One Earth Solar Farm

Environmental Statement Volume 3 – Figure 8.1 – 8.7

Document Reference: EN010159/APP/6.20.1

Details of changes made for Deadline 3 of Submission

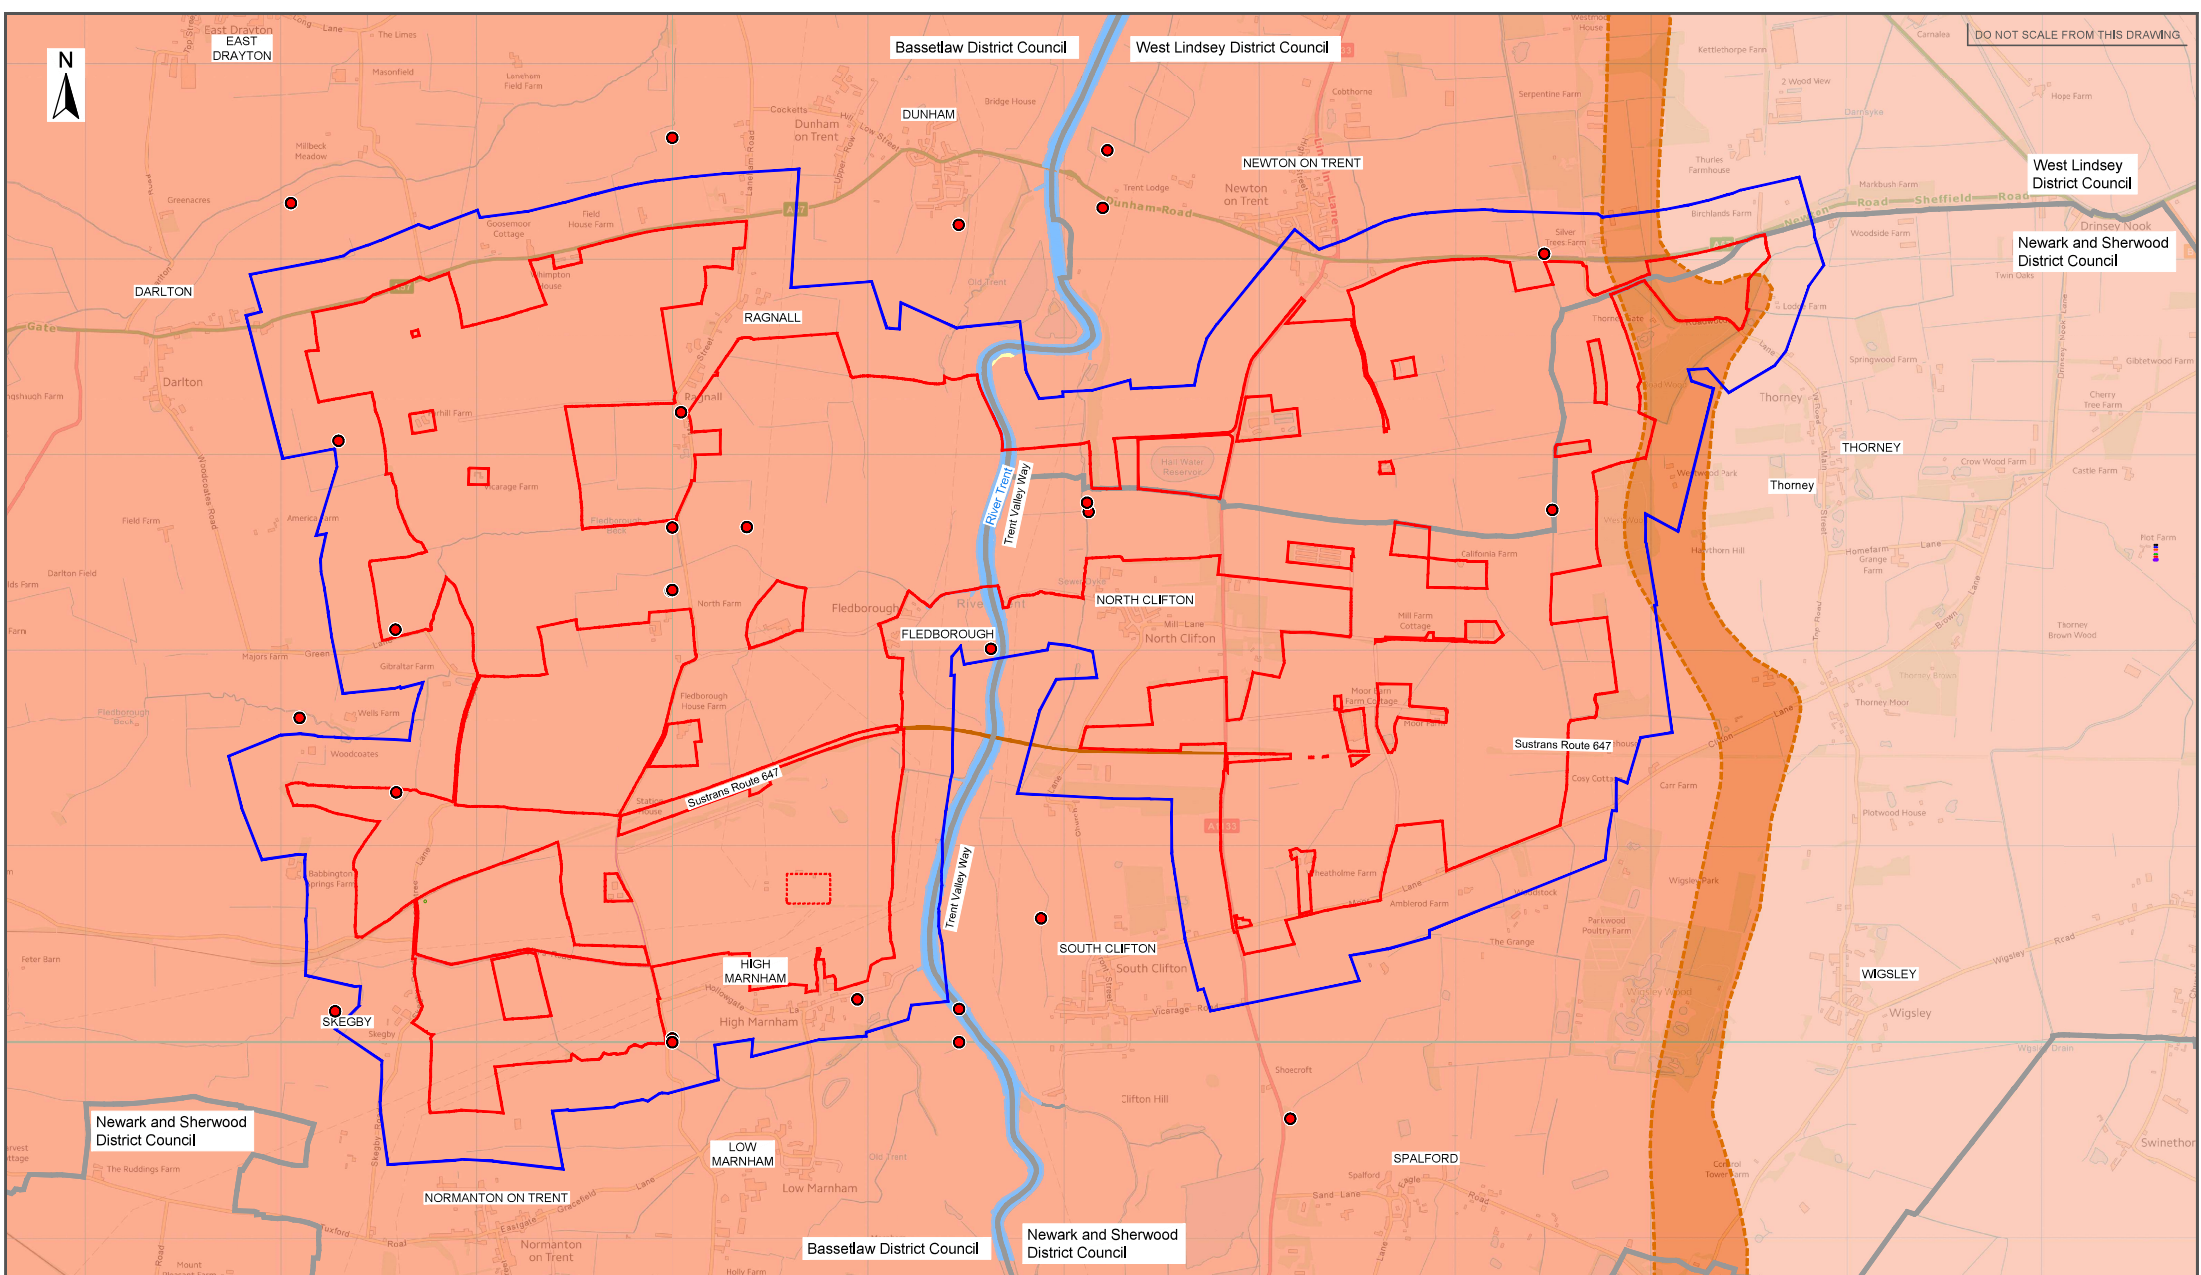
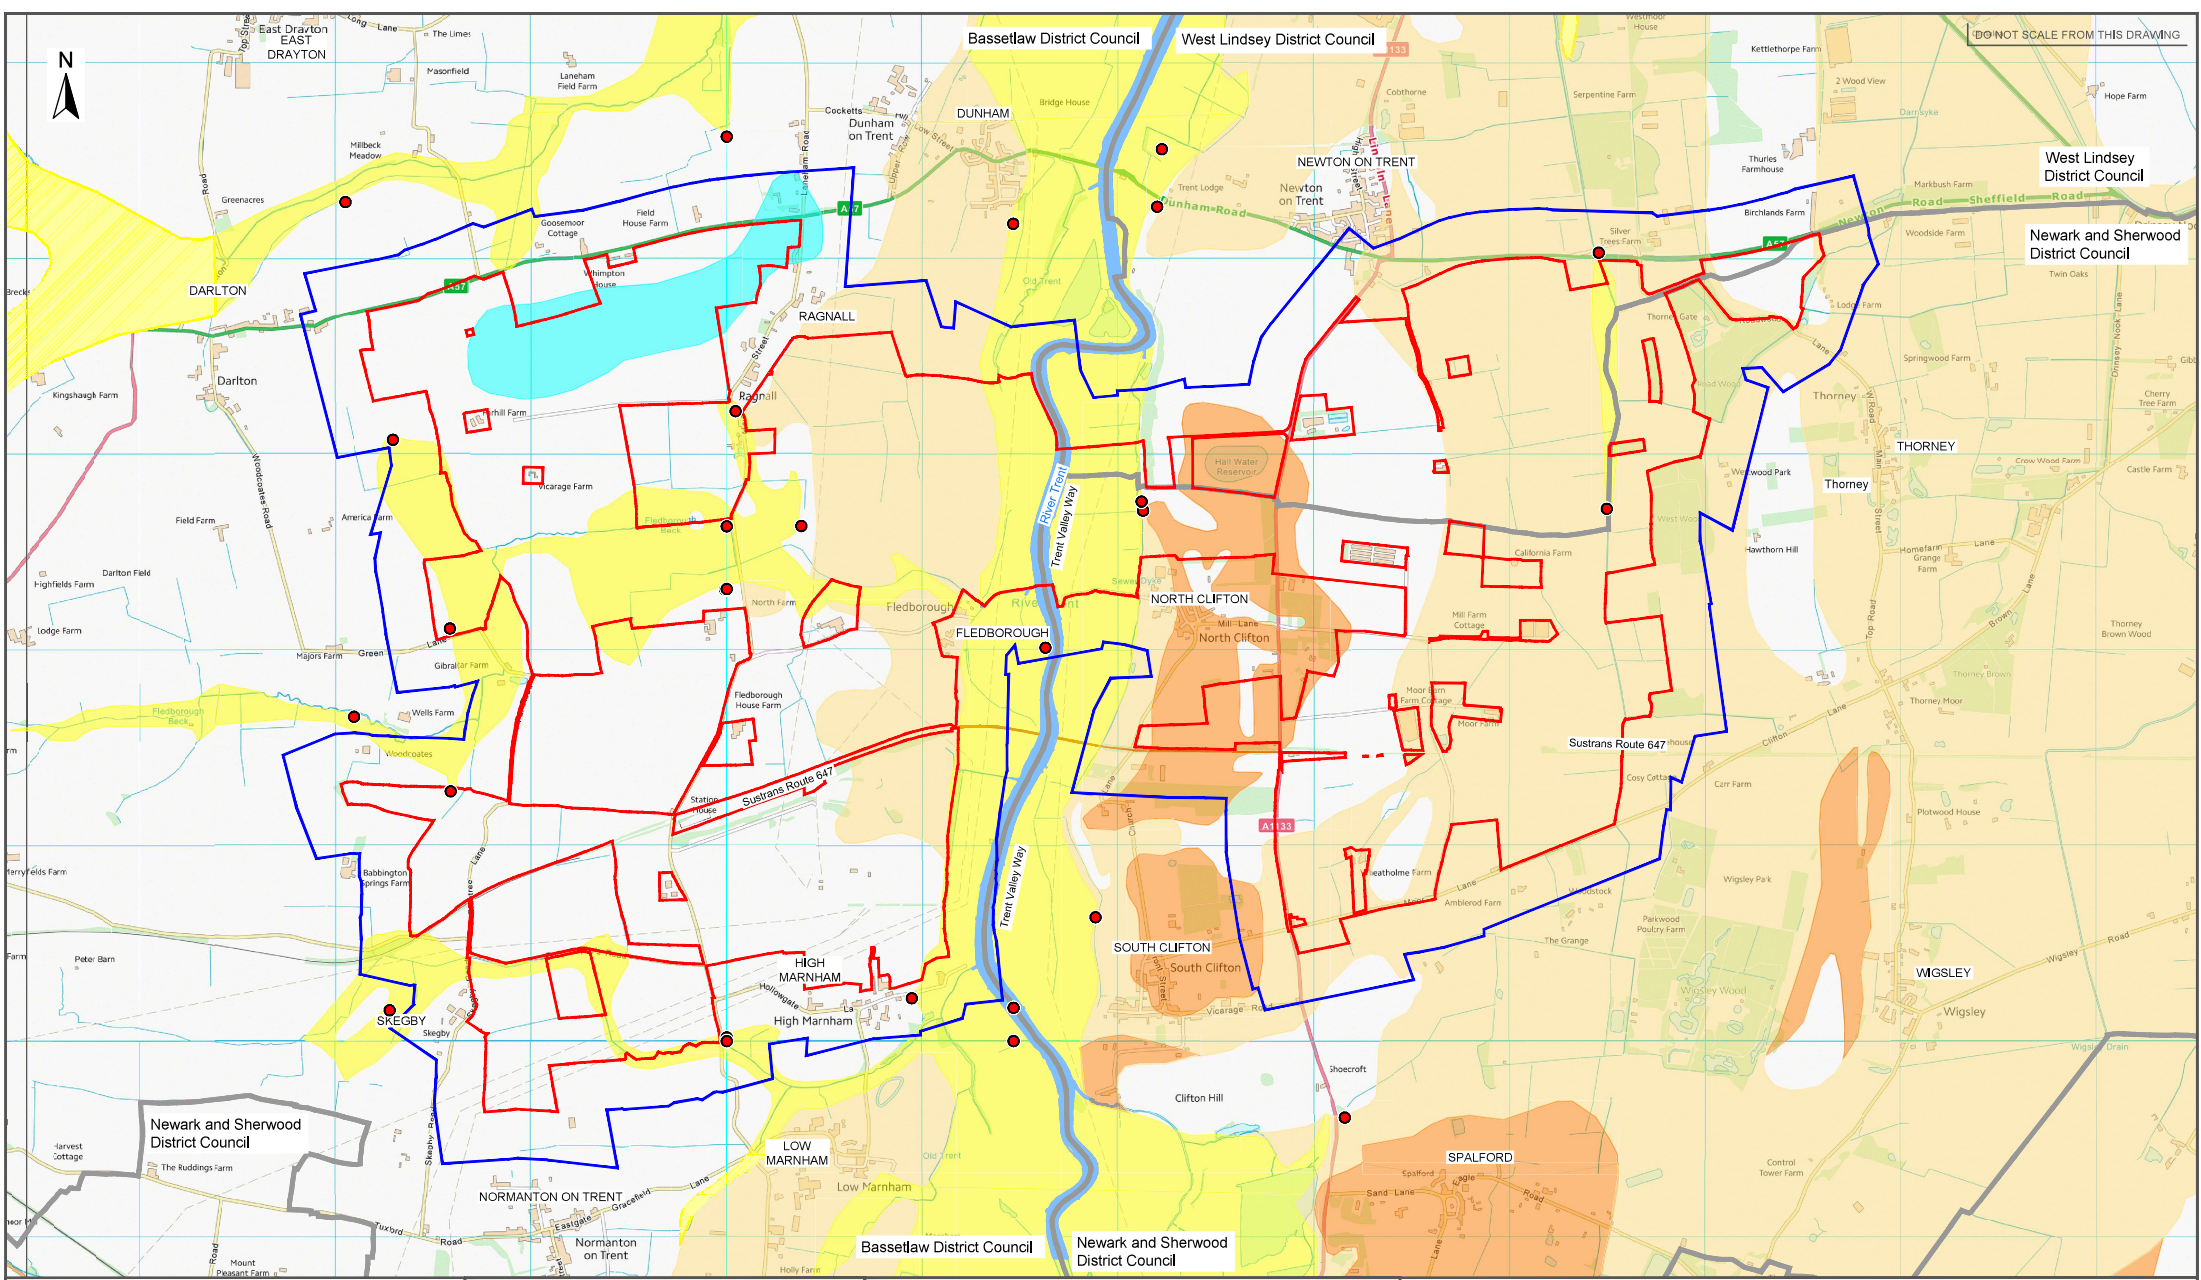
1. Hatching for landfill sites changed to red, and direction of hatching amended .
2. Boundary of historical landfill site close to Clifton Railway Station buildings amended for accuracy, which shows landfill site is outside Order Limits.

3. Incorrect area of yellow hatching to west of Clifton Railway Station removed.
4. Area of mothballed quarry shown on southern part of drawing removed as outside study area.

5. Groundwater abstraction zones outside study area to the north removed (as these are shown on Figure 8.7, and are not relevant on this drawing).
6. Colour of cross symbols changed to red for 'Location of historical waste management facility (Point location, not site area)'.

7. Colour of plus sign symbols changed to red for 'Location of licensed waste management facility'.
8. Boundary of sewage works facility to north east of Hall Water Reservoir amended, as this was incorrectly shown larger than actual extent.

9. Landfill site to north of High Marnham Power Station is both a landfill site and an area of water treatment works, so is amended to include both red and purple hatching.

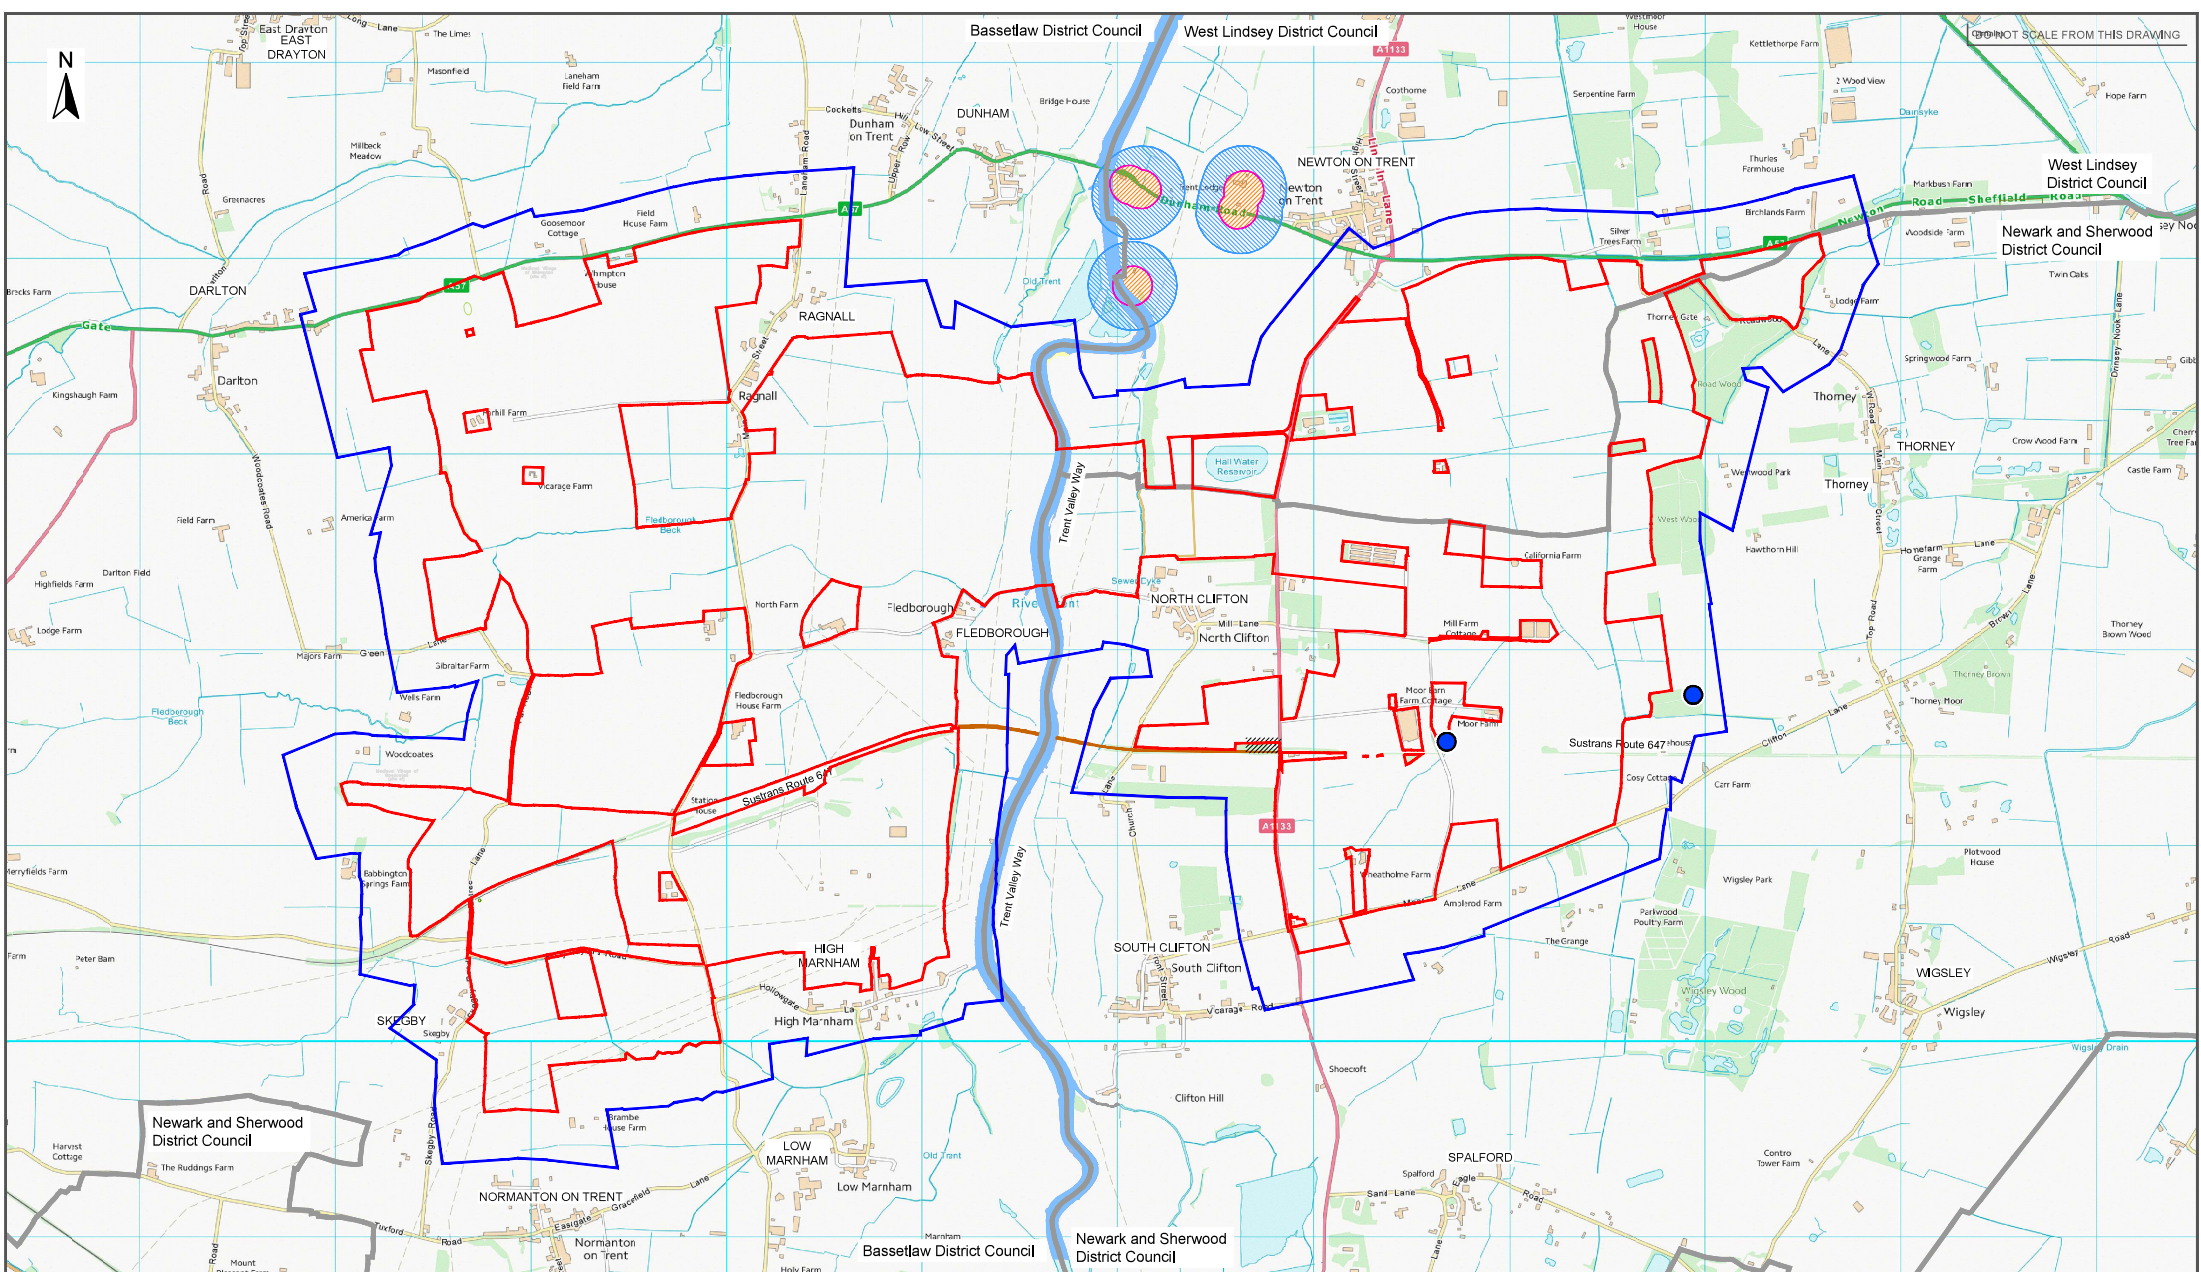
Dataset for active groundwater abstraction points has been updated (shown on the drawing as small blue circles).
